Date: 11th November 2015

Your Ref: A/131/15/RES

**CAR PARK LAYOUT AMENDMENTS – LAND SOUTH OF A259 AND WEST OF MILL LANE
(A/131/15/RES)**

Drawing Title
Proposed Plan

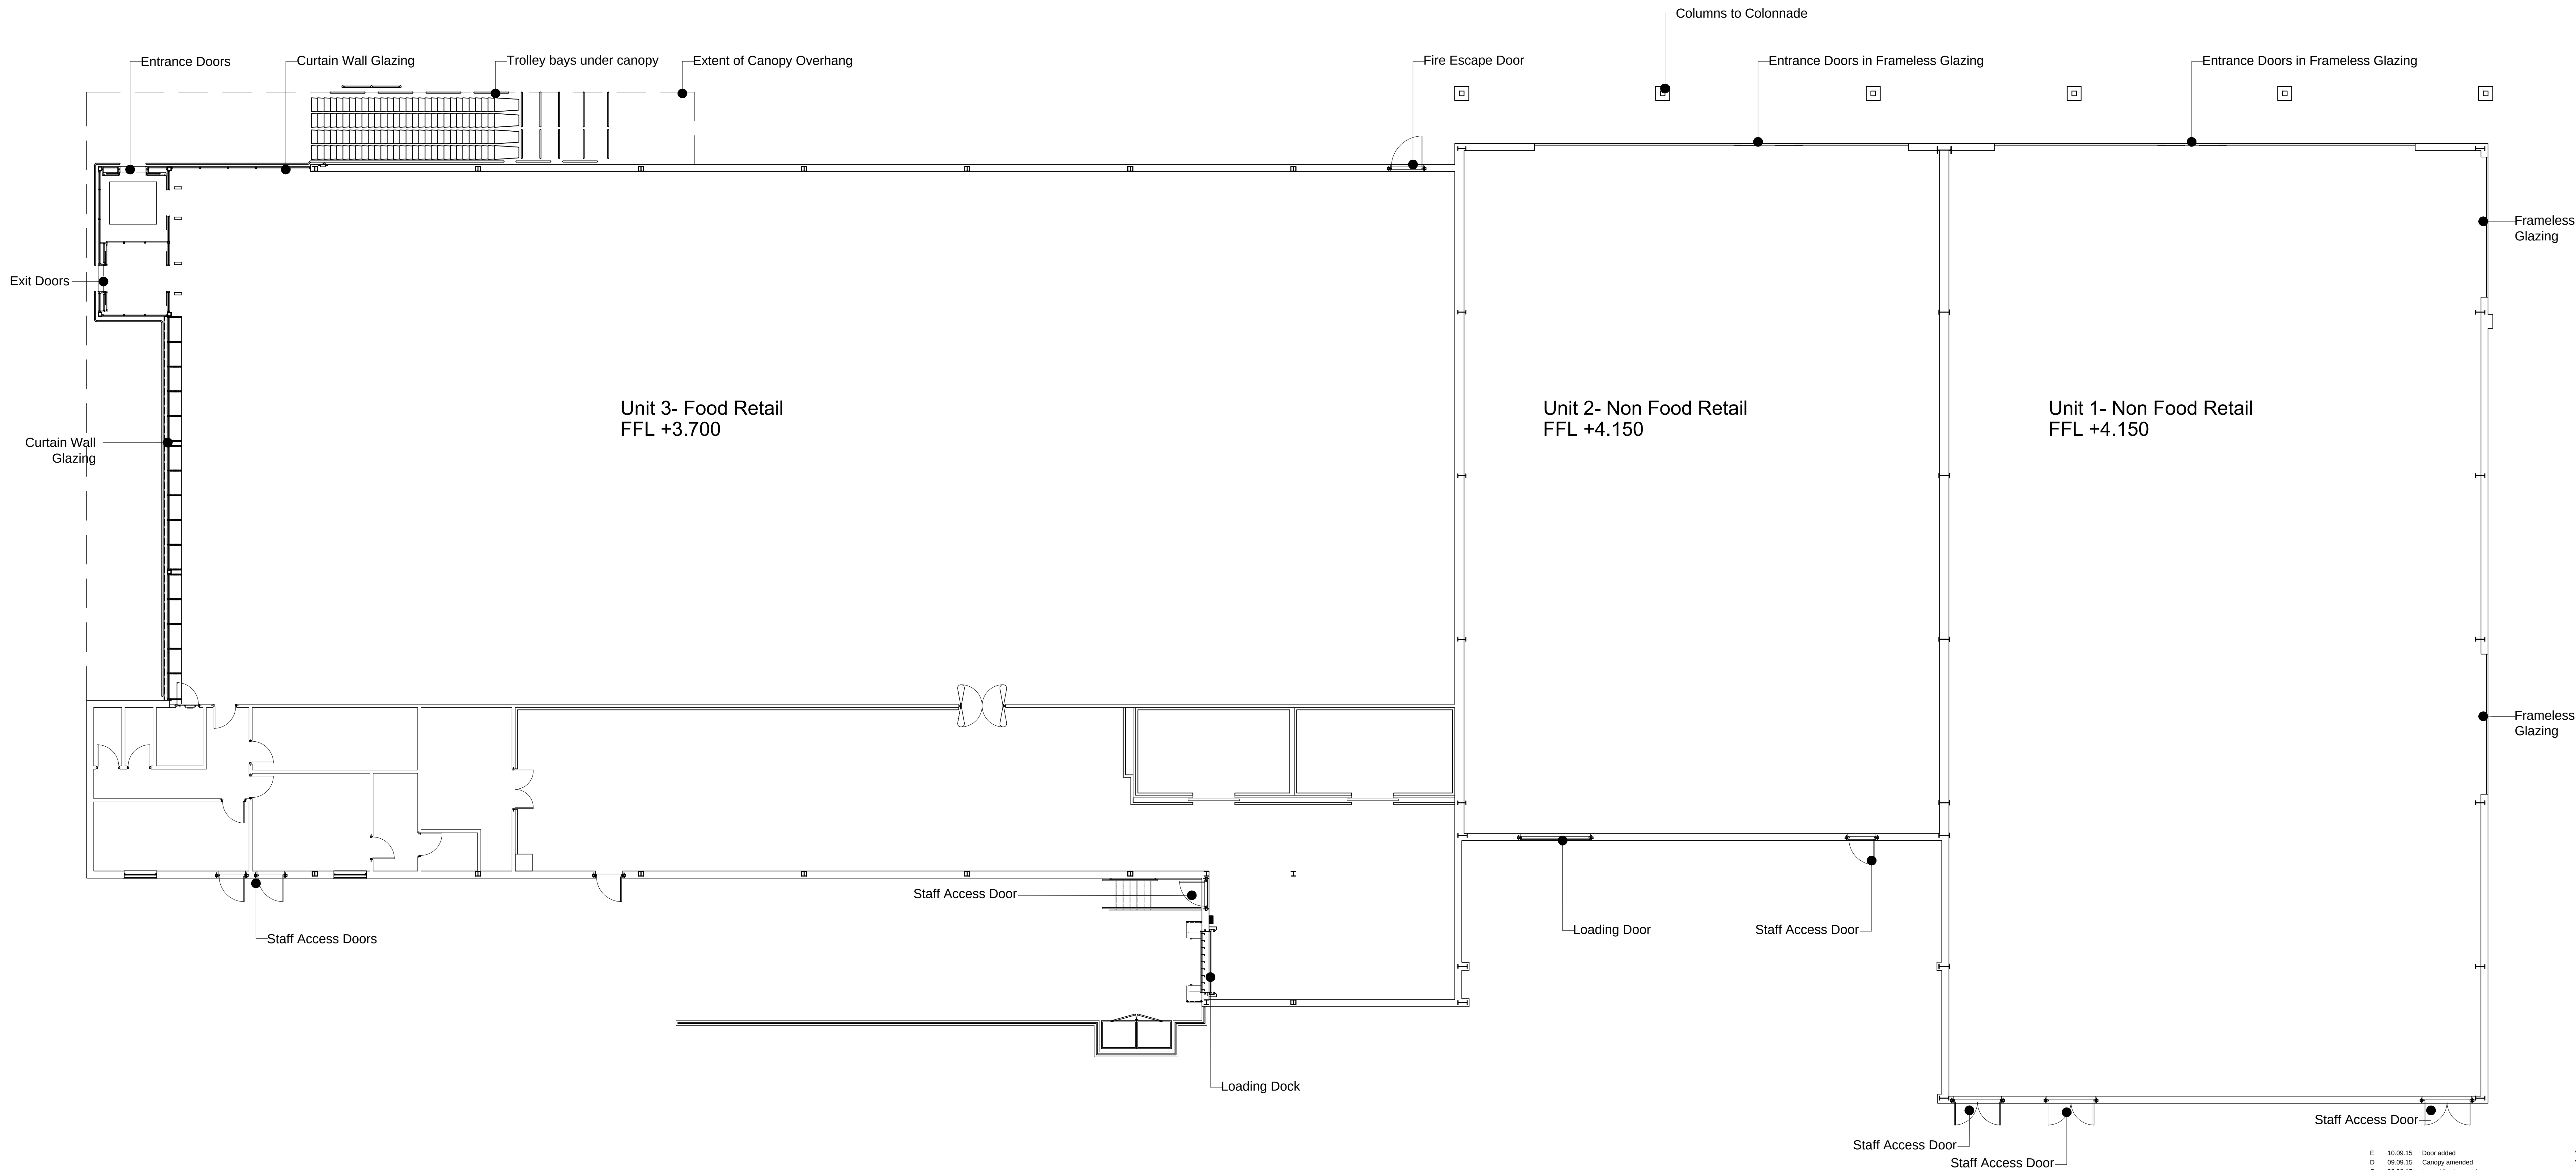
WSSC Query	Response
Number of car parking spaces	The planning application drawings have been amended to address the issues raised in the WSSC response. This has had knock on impacts in terms of the quantum of car parking provided. The application drawing propose 227 spaces. Given that the proposed parking layout complies with the planning condition above (i.e. it is greater than 190 spaces), we hope that the parking layout will be acceptable in terms of the quantum of car parking provided. The number of additional staff spaces provided is 8.
Car parking bay dimensions and geometries	The planning drawing has been amended to include dimensions for car parking bays and walkways.
Swept path analysis of car parking spaces	Please find enclosed the swept path analysis as requested.
Cycle parking provision	The application drawing has been amended to include 30 cycle parking spaces. This is greater than the minimum of 16 specified by the condition and therefore we trust that the proposed provision will be acceptable in this regard. Greater clarity has also been provided in respect of staff cycle spaces (30 spaces provided).

Motorcycle parking provision	The application drawing has been amended to include 8 motor cycle spaces.
Aisle width of internal road	The application drawing has been amended to include dimensions of roadways.
Crossing point	The application drawing has been amended to show one further crossing point to the eastern edge of the buildings from the north as suggested by WSSC.
Staggered gate	The application drawing has been amended to incorporate a staggered gate at the end of the cycle route as suggested by WSSC.
Tracking of service vehicles	Please find enclosed as requested tracking by the largest vehicle to use the servicing turning head. This demonstrates that the manoeuvre can be successfully undertaken.

We trust that proposed changes and additional information will be favourably received by West Sussex County Council, and in this event, we would be grateful if drawing reference 6165-003L could be substituted for those previously submitted. Should you have any queries in respect of the attached, please do not hesitate to contact Sally Miles or myself.
